Our Reference: NCA/6/2011
Contact: Liam Frayne
Telephone: 9806 5595
Fax: 9806 5917

9 December 2014

**MP 09_0167 Mod 4 – Modification to Approved Mixed Use Development
45 – 47 Macquarie Street and 134 – 140 Marsden Street, Parramatta**

i. Street Context Elevations

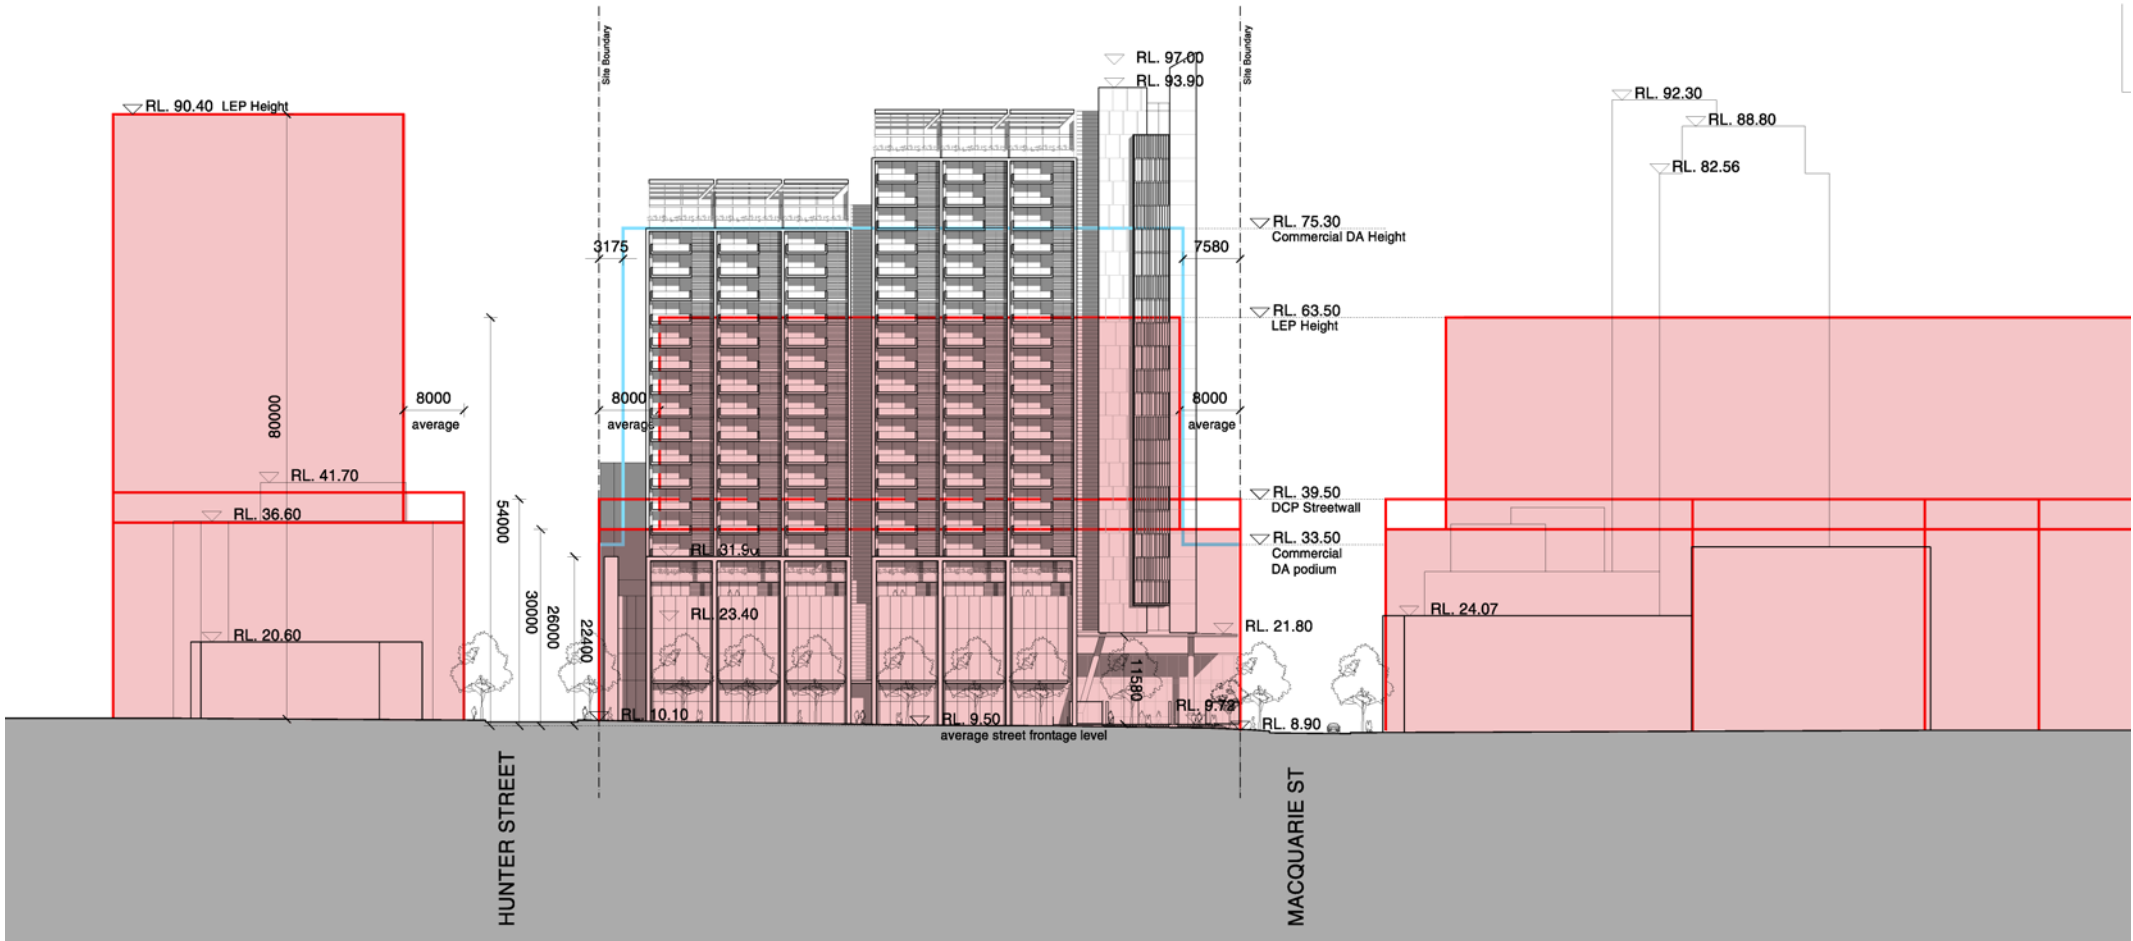
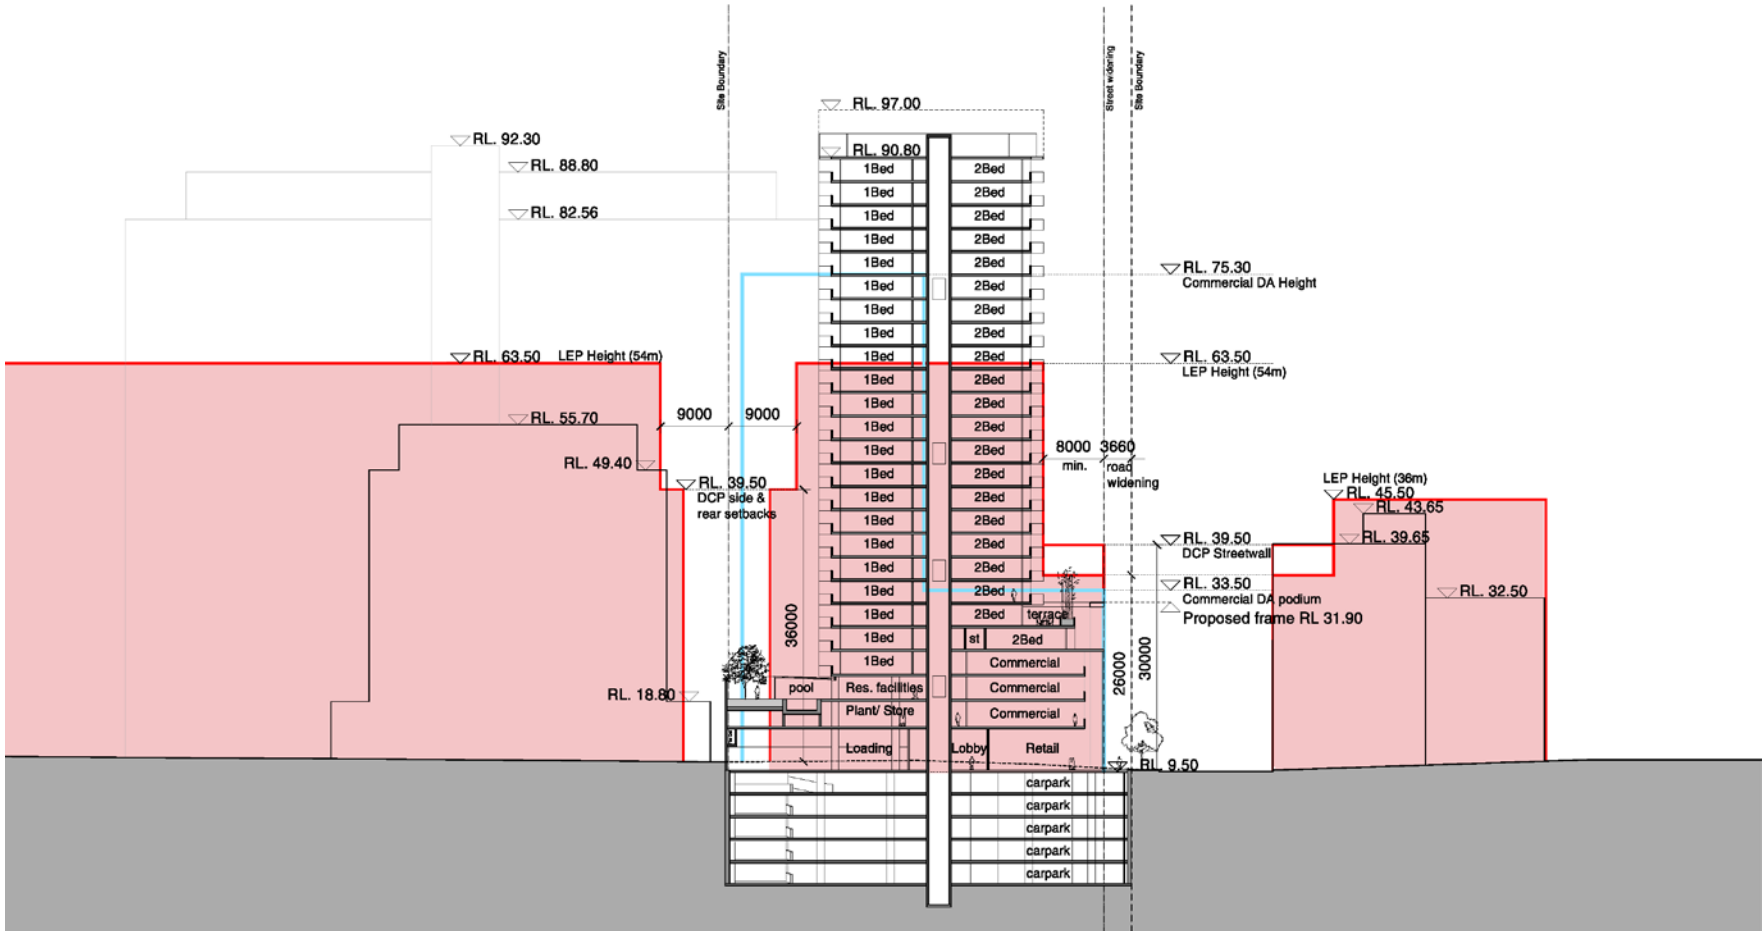
(b) The approved south elevation has a distinction between the expressed verticality of the tower and the lower south wing. In contrast, the modified south elevation lacks compositional clarity given the distinction between the taller and shorter elements has been diminished. It is requested that consideration be given by an urban designer/architect as to how this issue might be resolved.
